SUBJECT: Engineering Review Comment
Mountain View Electric Association Inc. (The Association)

Project Name: Cloverleaf Filing 1 – Final Plat

Project Number: SF2114

CLOVERLEAF FILING NO. 1

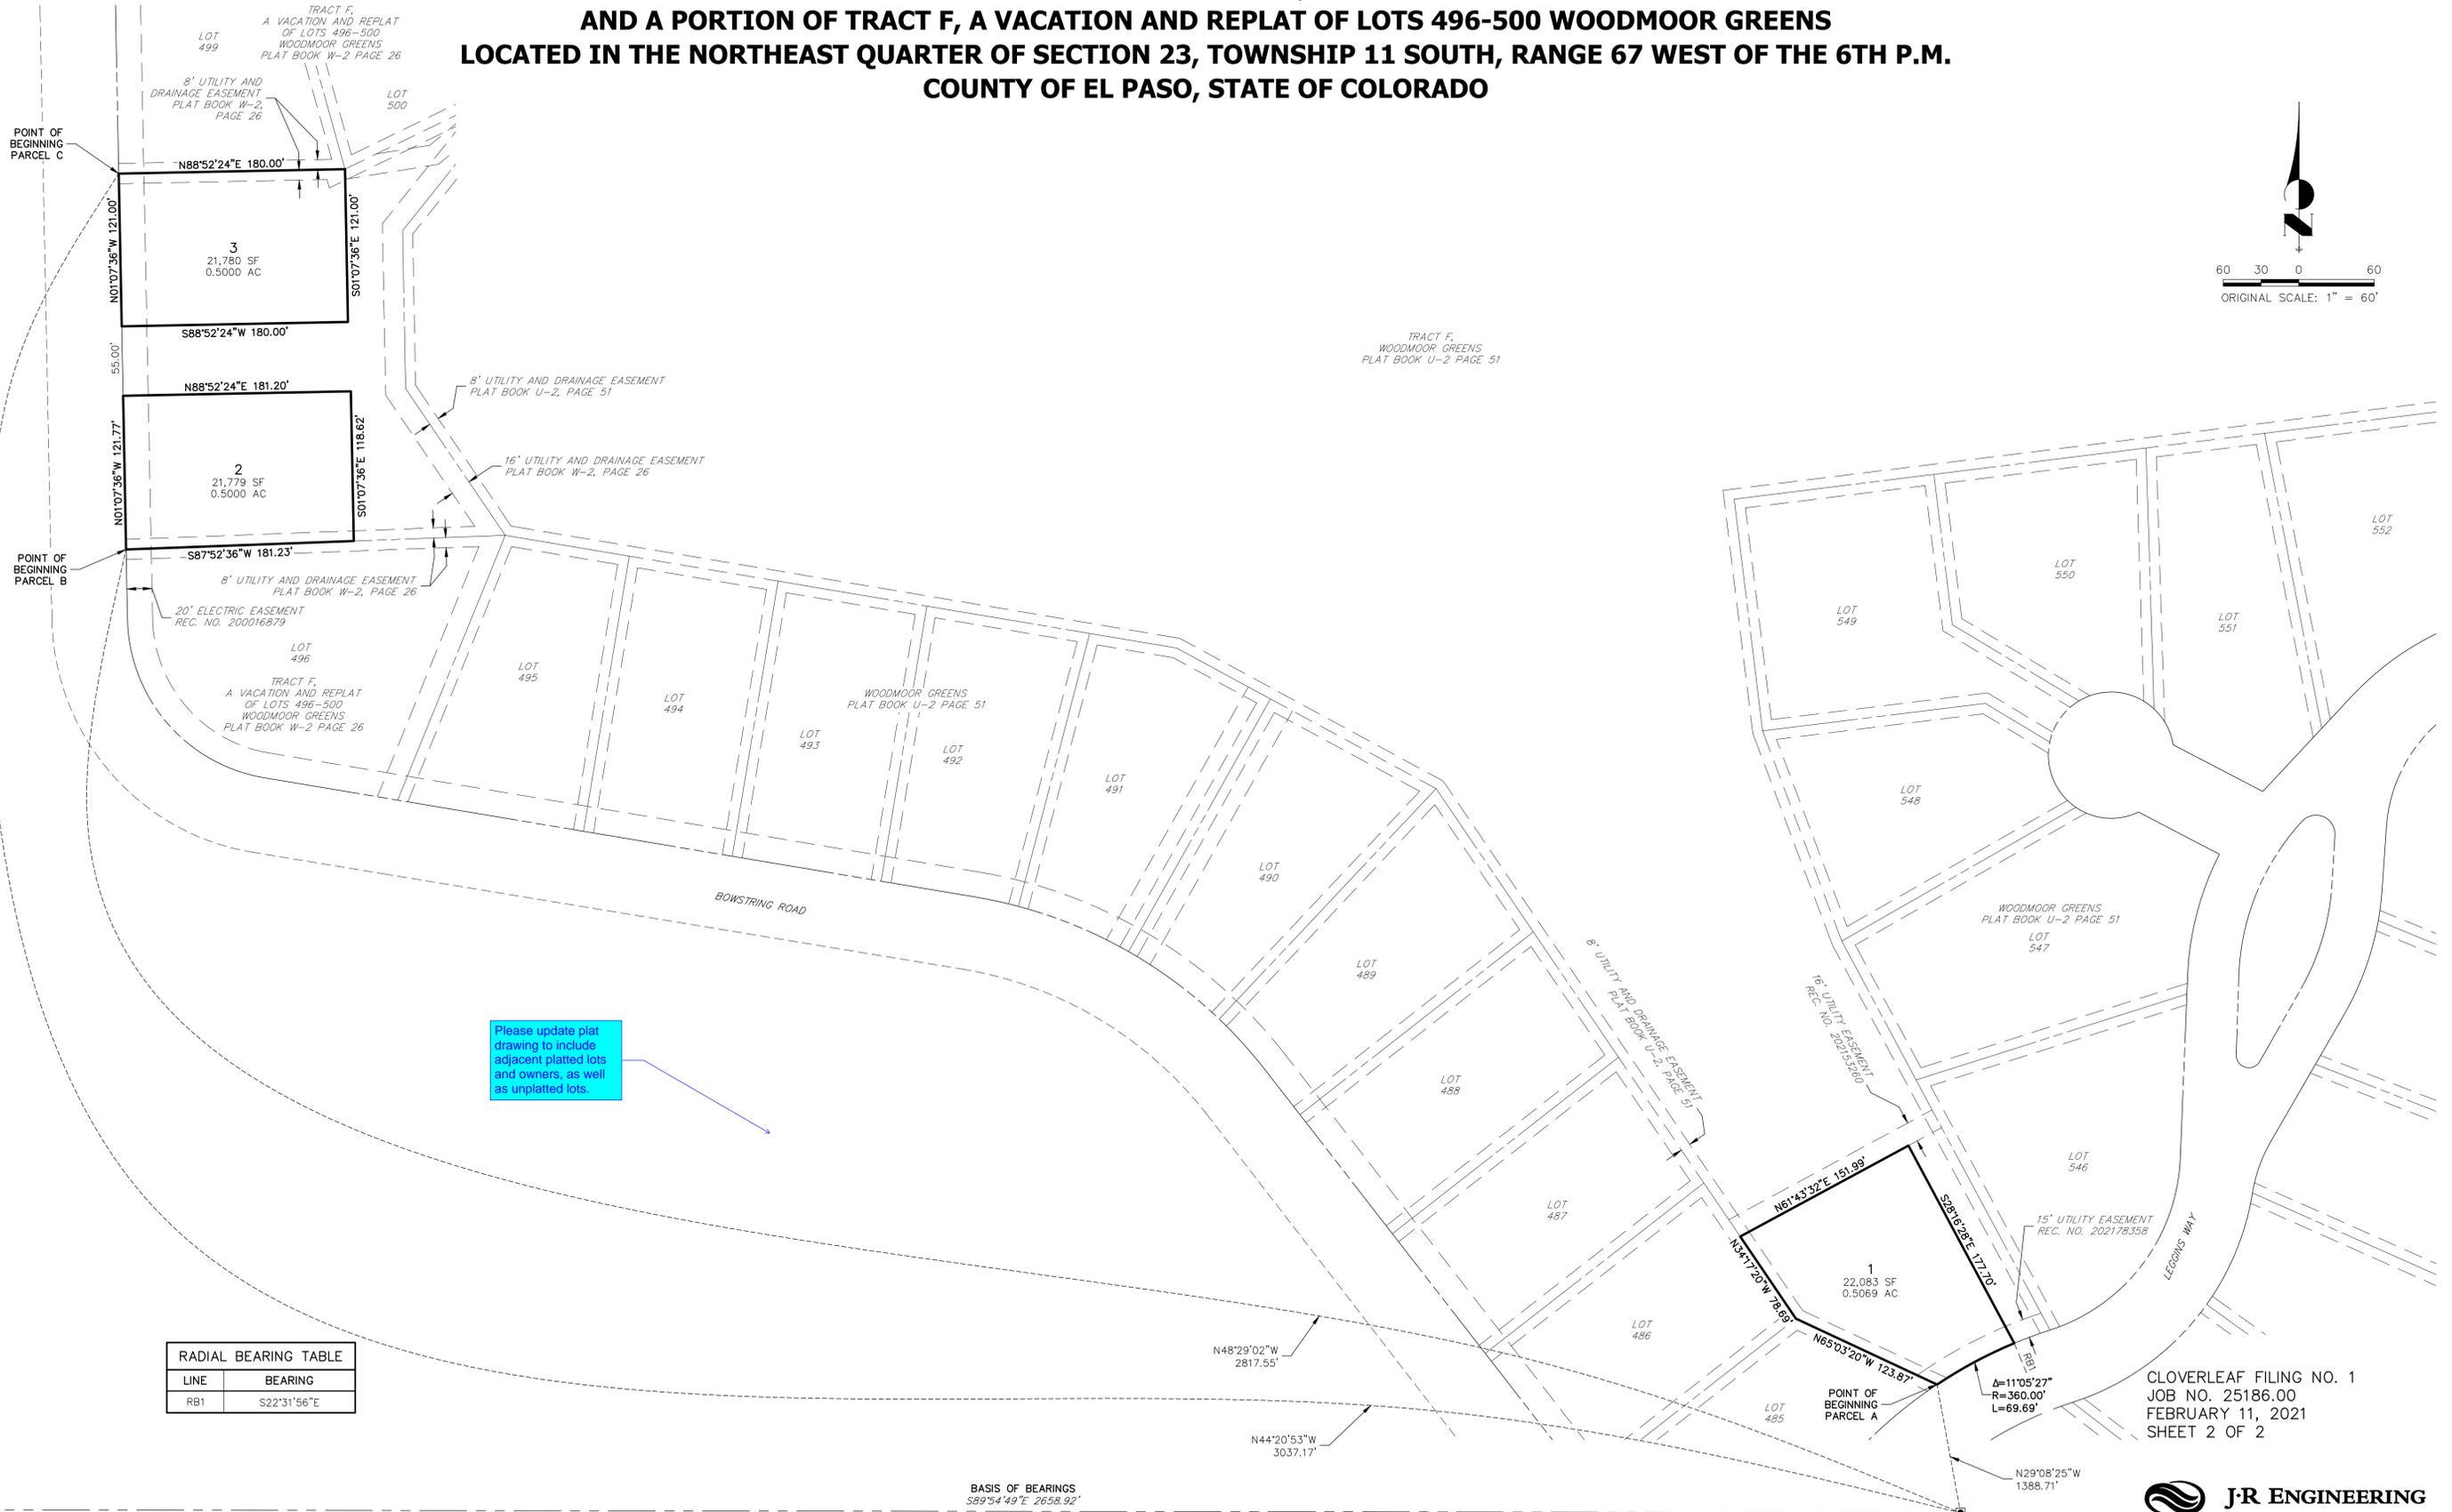
The Association requests a ten (10) foot front lot utility easement, a ten (10) foot side lot utility easement, and a seven (7) foot rear lot utility easement along with a twenty (20) foot exterior utility easement on the plat. The Association also requests the platting of the Association's existing facilities with easement on the plat. Additional easements may be required.
